**ADC Planning Consultation
Conservation/Design Officer Response**

Application Number	AL/40/17/L
Address	17 Aldingbourne House, Aldingbourne
Description	Alteration to the fenestration of a listed building
Case Officer	Richard Temple
Date	31 May 2017

Flat 17 Aldingbourne House
Crackerhill PO18 0LQ

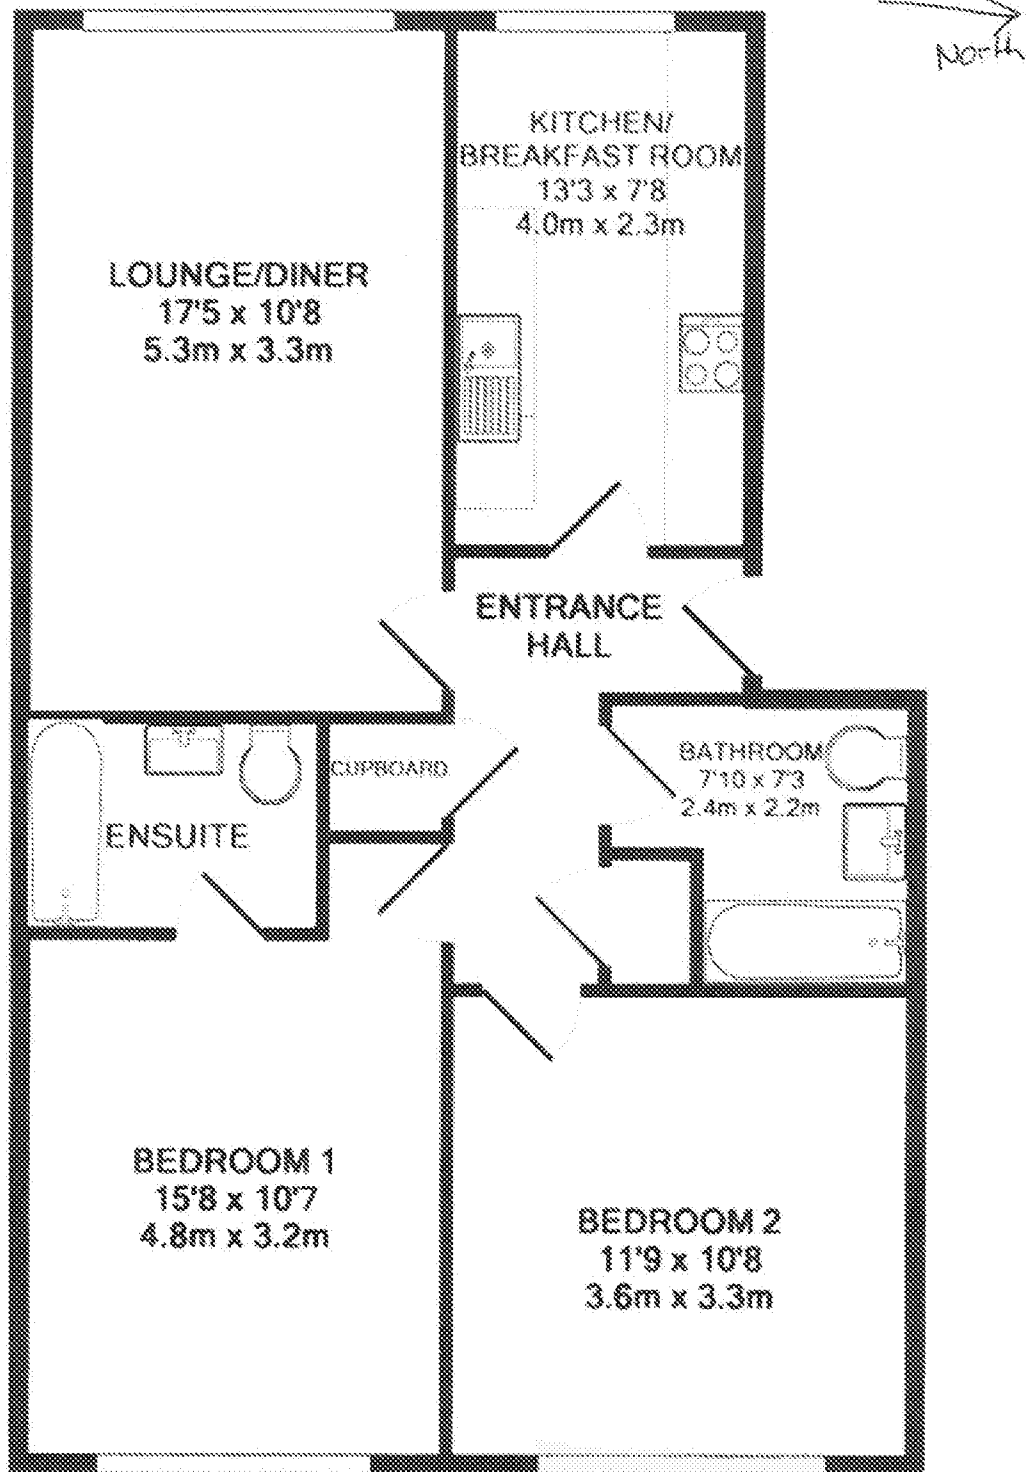
The documentation submitted in support of this proposal is far from sufficient to allow a full understanding of its potential impact on the significance of the heritage asset. (Ref. NPPF para 128)

However the photographs of an unidentified elevation of the listed building where the works are to occur demonstrate that uniform fenestration is a key architectural feature. The proposal to replace one of the six, strictly symmetrical windows with a door results in loss of existing fabric and causes considerable harm to the distinctive building aesthetic.

It is noted that the subject range is part of the later additions to the north of the original House. However it is part of the evolution of the heritage asset and its starkly symmetrical frontage acts as an effective foil to the more richly embellished form of the House. While the later range may be of less intrinsic interest, it nevertheless makes an important contribution to the significance of the designated heritage asset as a whole.

The proposal is thus contrary to Para. 132 of the NPPF, which requires great weight to be given to the conservation of designated heritage assets and notes that significance can be harmed or lost through inappropriate alteration. Refusal is therefore recommended in terms of Policy HER DM1.
